Blacktown
City Council

Your ref: **SSD-36138263**
File no: MC-20-00005

SSD-36138263 Augusta Street Warehouse and Distribution Centre

Blacktown Council's submission to SSD-36138263 Augusta Street Warehouse and Distribution Centre

1 MASTERPLAN
1: 1500

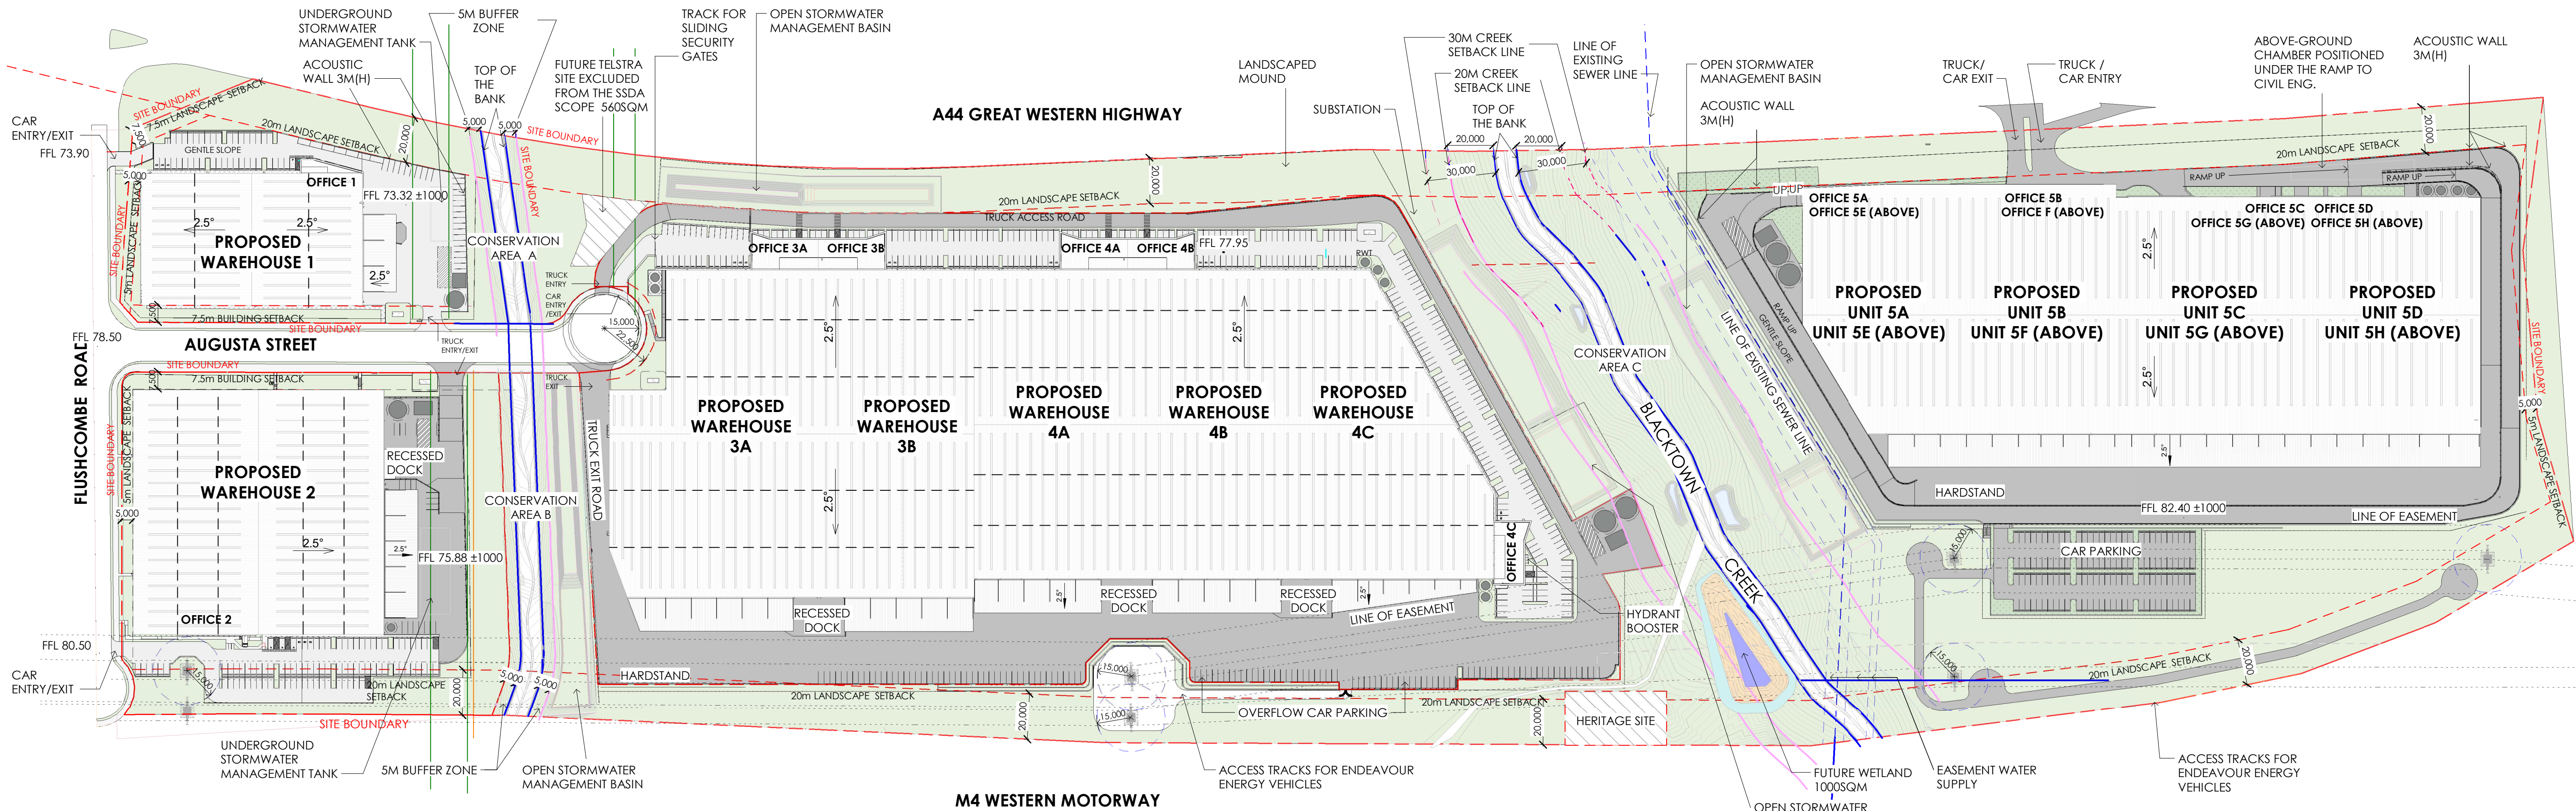
2. Warehouse 5 does not comply with the minimum 20m setback from Prospect Highway requirement in the north-eastern corner of the development.
3. All fire tanks are to be suitably screened as the present form is unsightly and a visual eye-sore.

1 BUILDING 2- SITE & WAREHOUSE PLAN
1 : 500

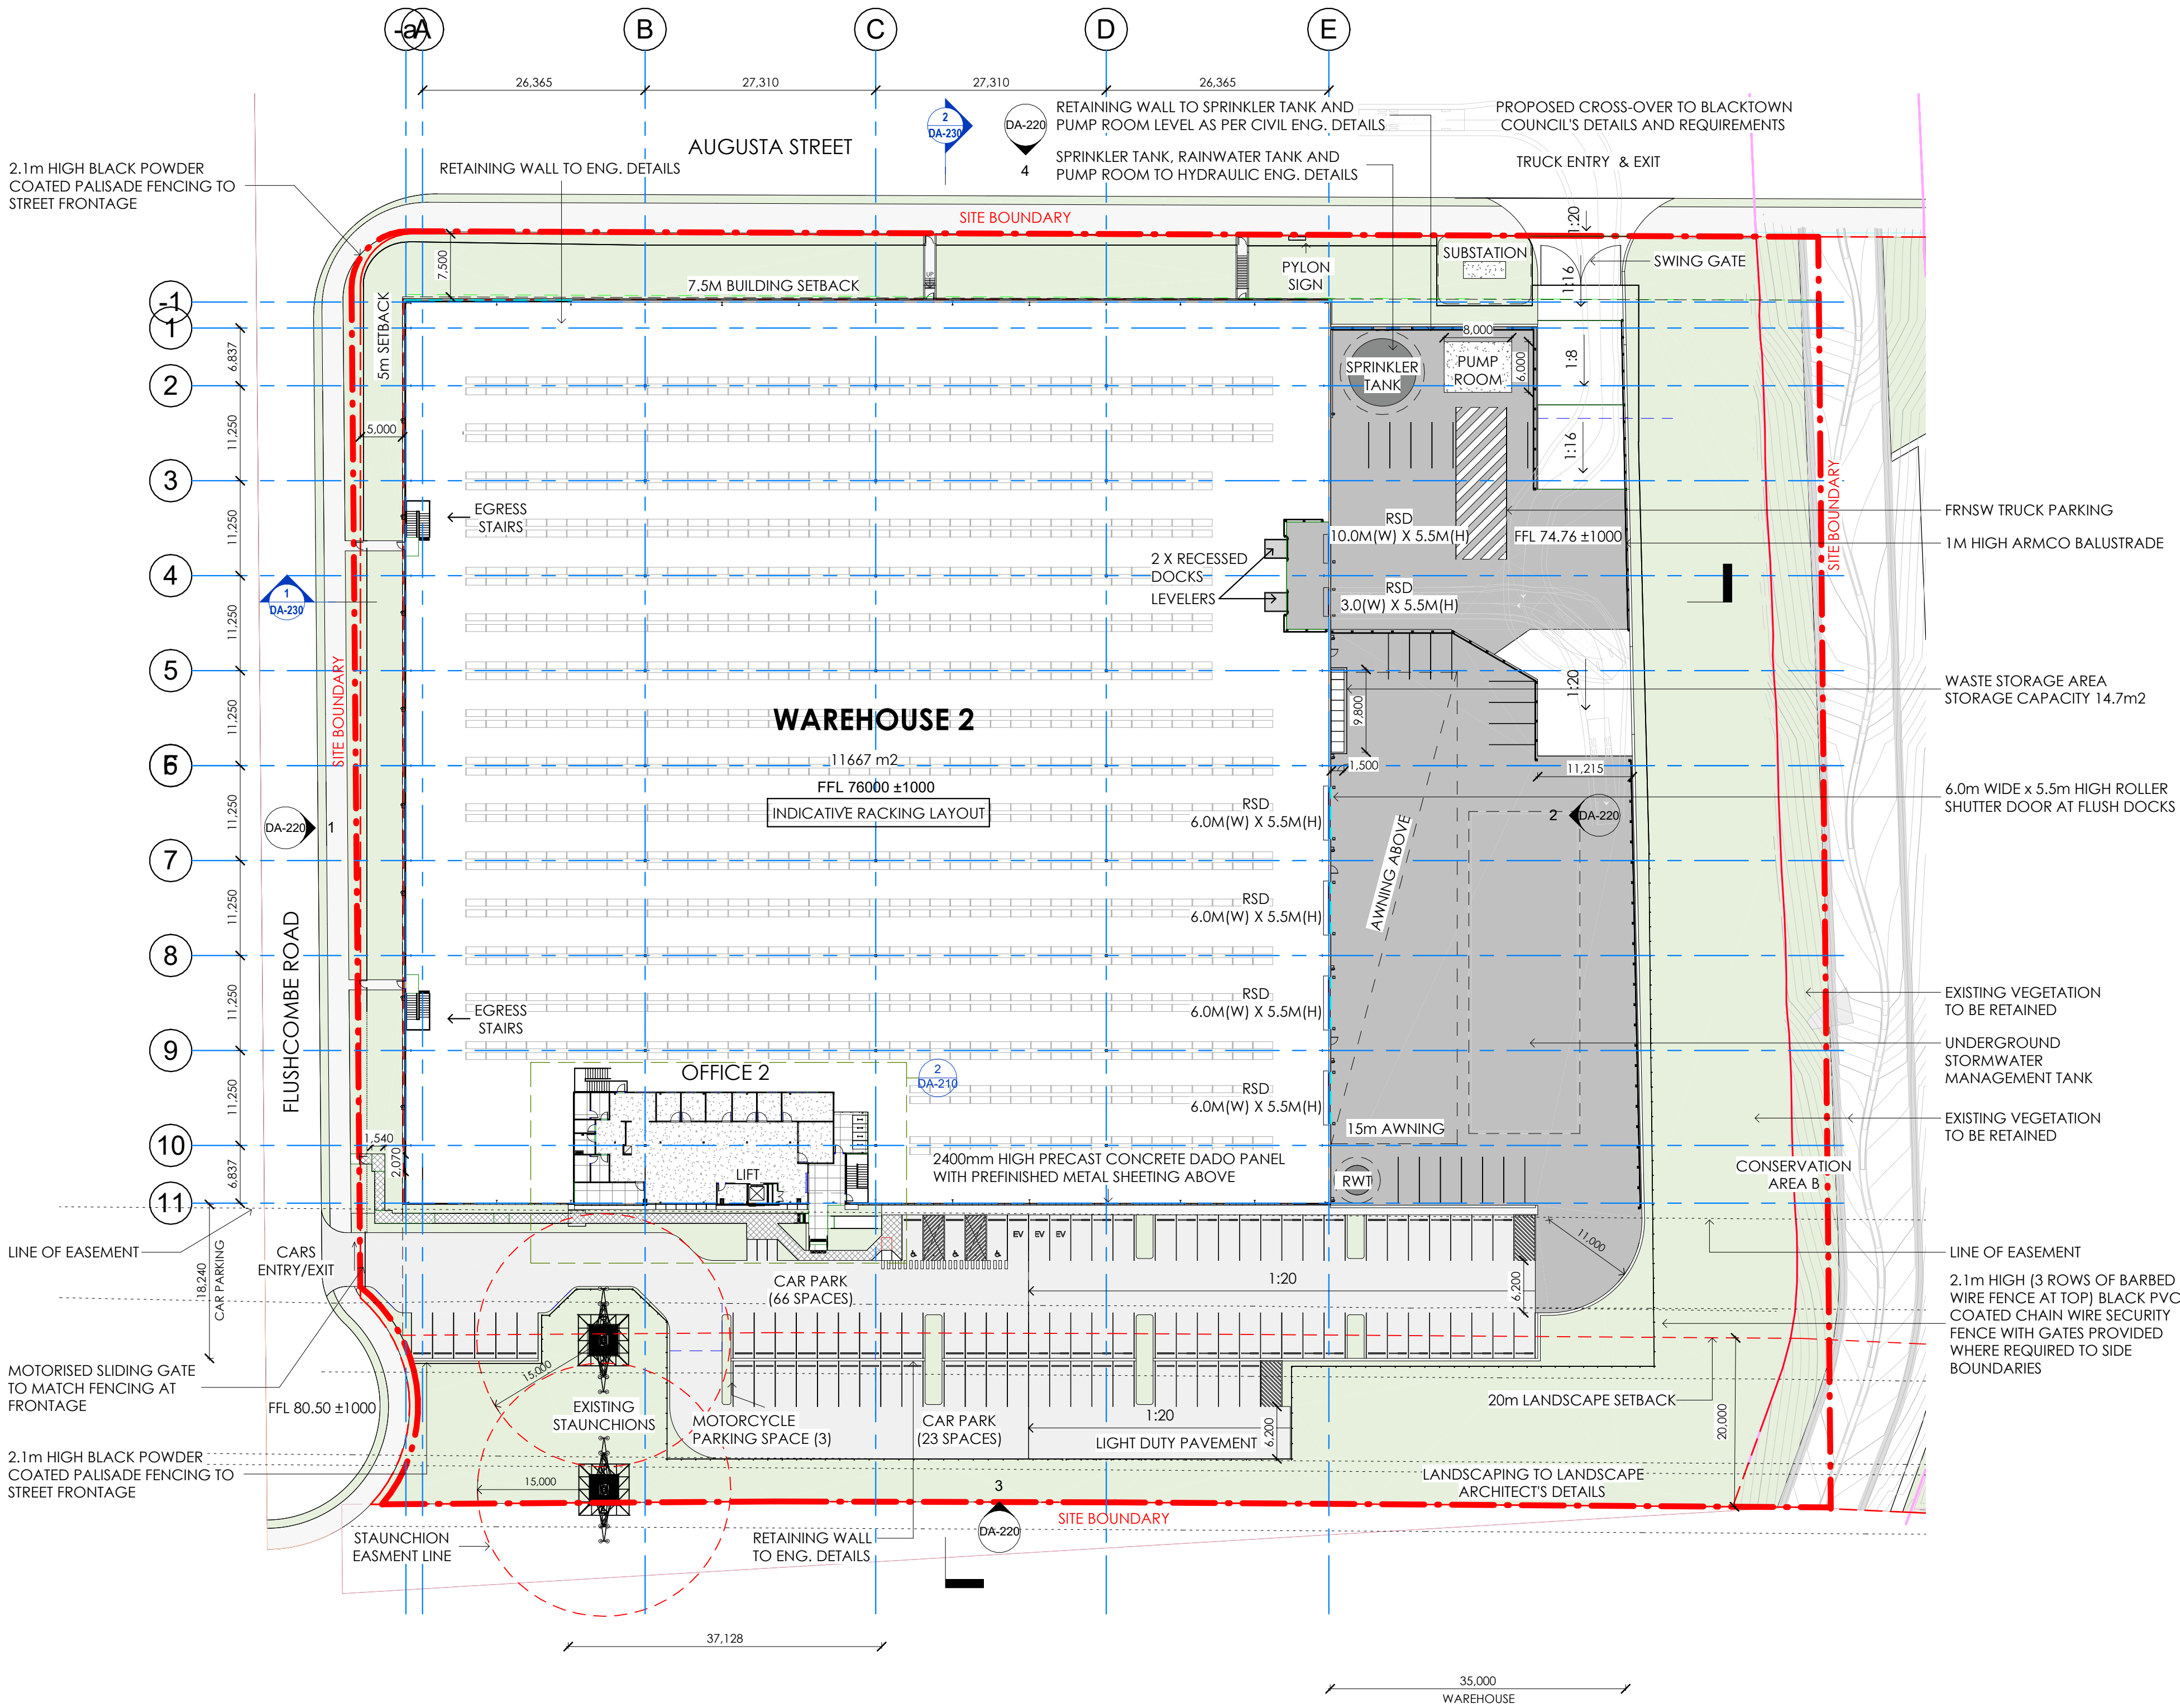
1. The Pre-Application Meeting held in June 2022 required that all setback areas were to be landscaped and maintained as open areas only, so as to enhance the streetscape appearance of the development. Council will not support car parking and internal vehicle manoeuvring except proposed driveways within these setback areas. The proposal does not comply in this regard as parking areas have been placed within the 20m southern setback to the M4 Motorway for Warehouse 2.
